## DEPARTMENT OF PUBLIC WORKS

### MEMORANDUM

**TO:** All Staff  
**FROM:** Public Works Plan Review Team  
**DATE:** July 8, 2025  
**SUBJECT:** CB-25-00004 Mason

Site Plan

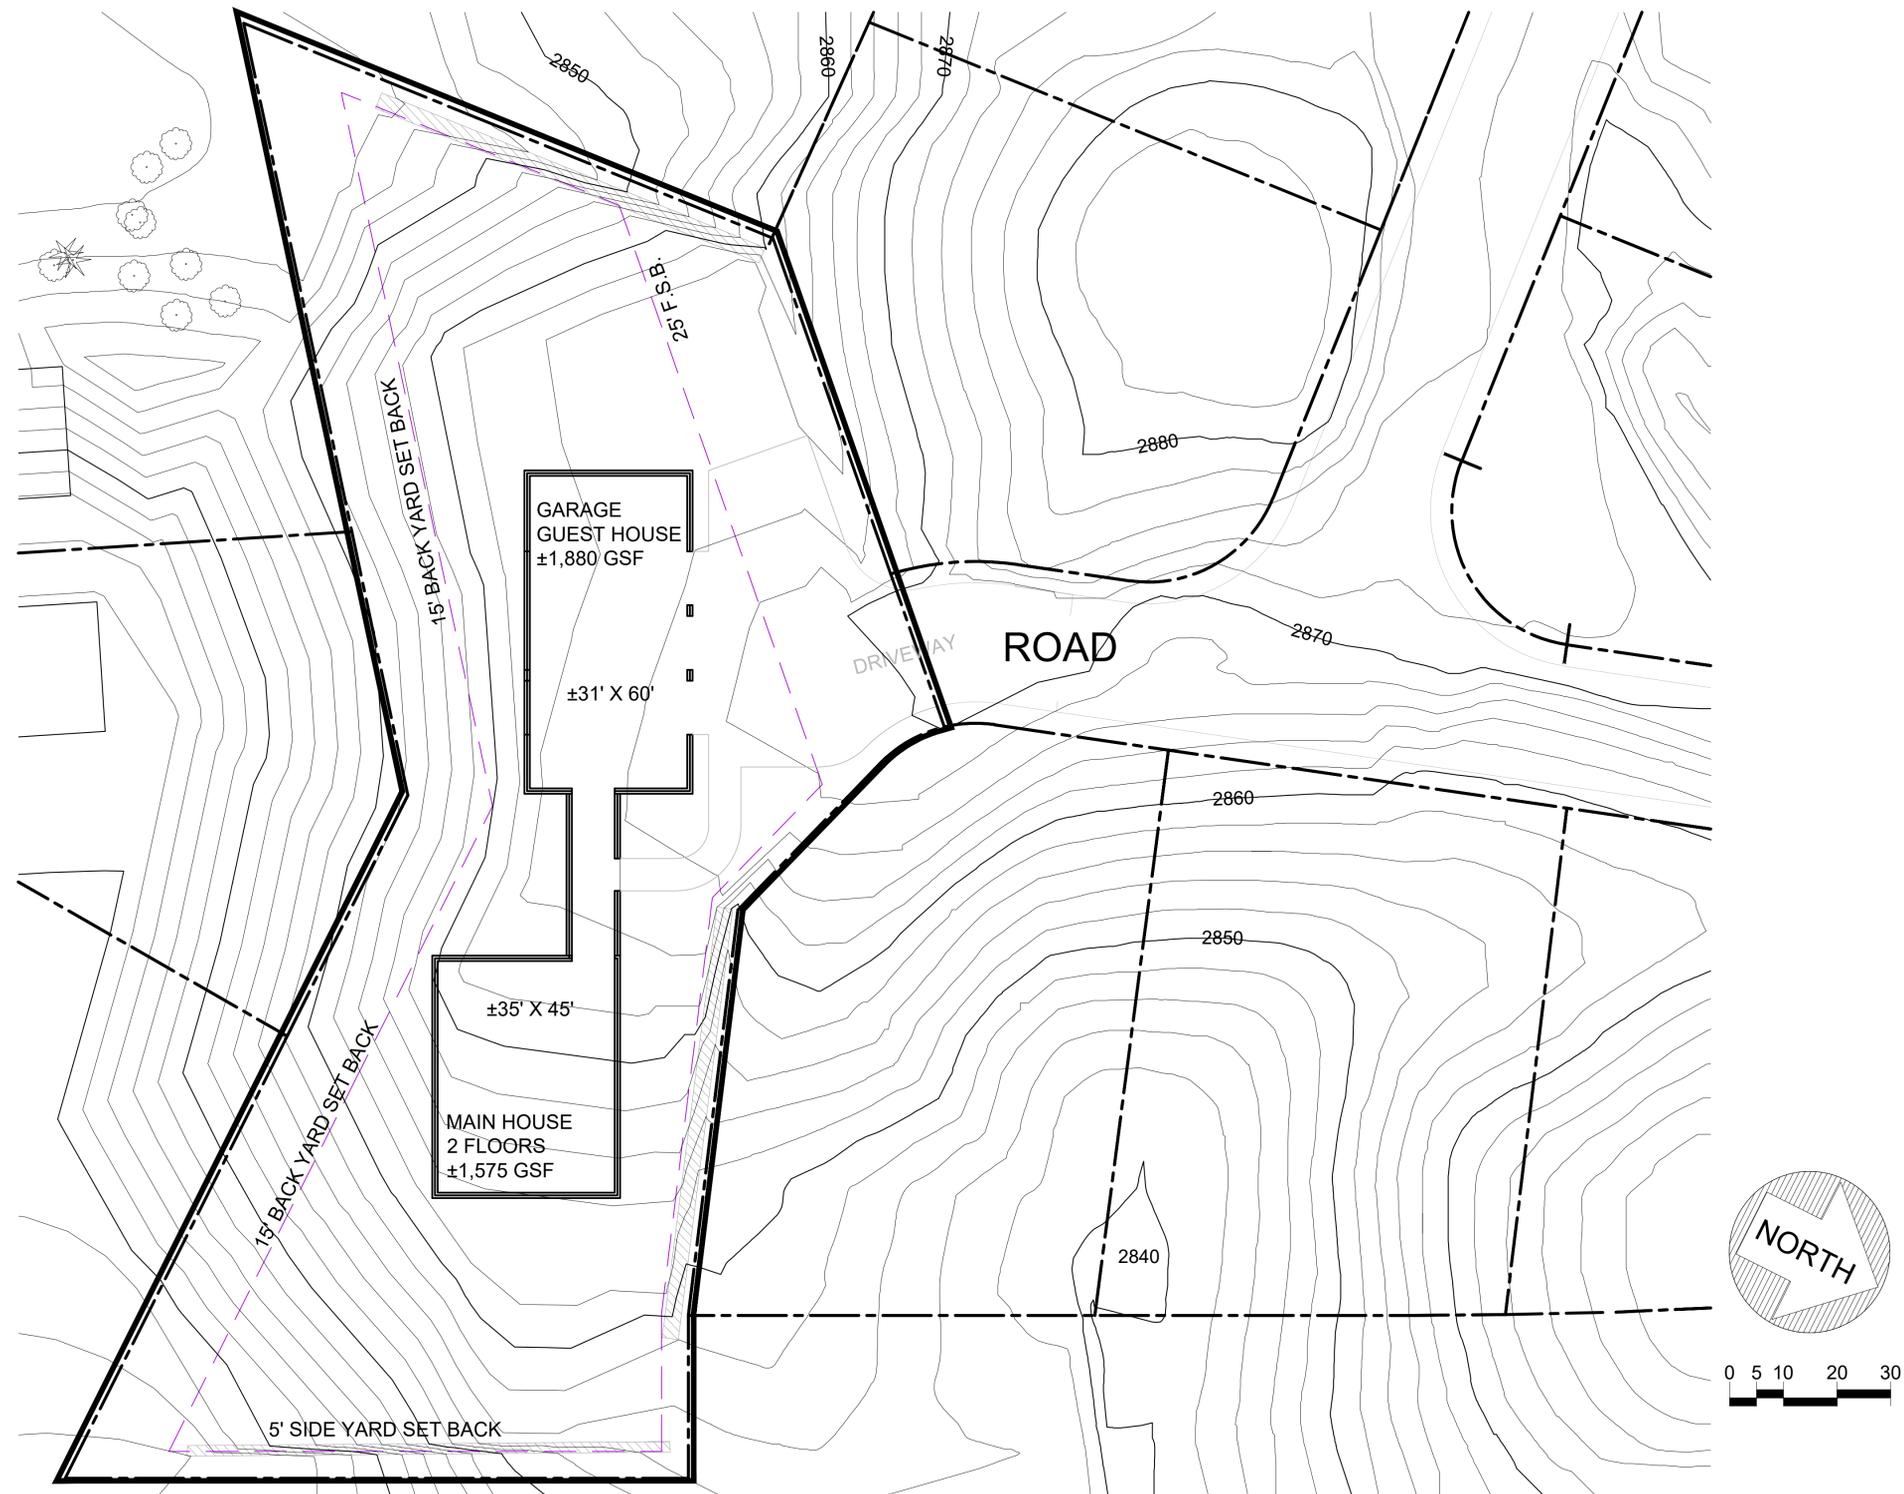
<b>SURVEY</b>	<p>The following survey comments are not intended to prevent the Parcel Combination, but just put to notify the applicant and building department of potential impacts to the proposal.</p> <ol style="list-style-type: none"> <li>1. Per the original Plat of Ski Acre Estates, there is a 10' wide drainage easement through Lot 23. Please provide evidence that this was vacated, or show its location in relation to the proposed building, to show that it falls outside building envelope. (JT)</li> </ol>
<b>TRANSPORTATION CONCURRENCY</b>	No Comment.(RC)
<b>FLOOD</b>	No comments. (SC)
<b>WATER MITIGATION/ METERING</b>	No comments. (SC)
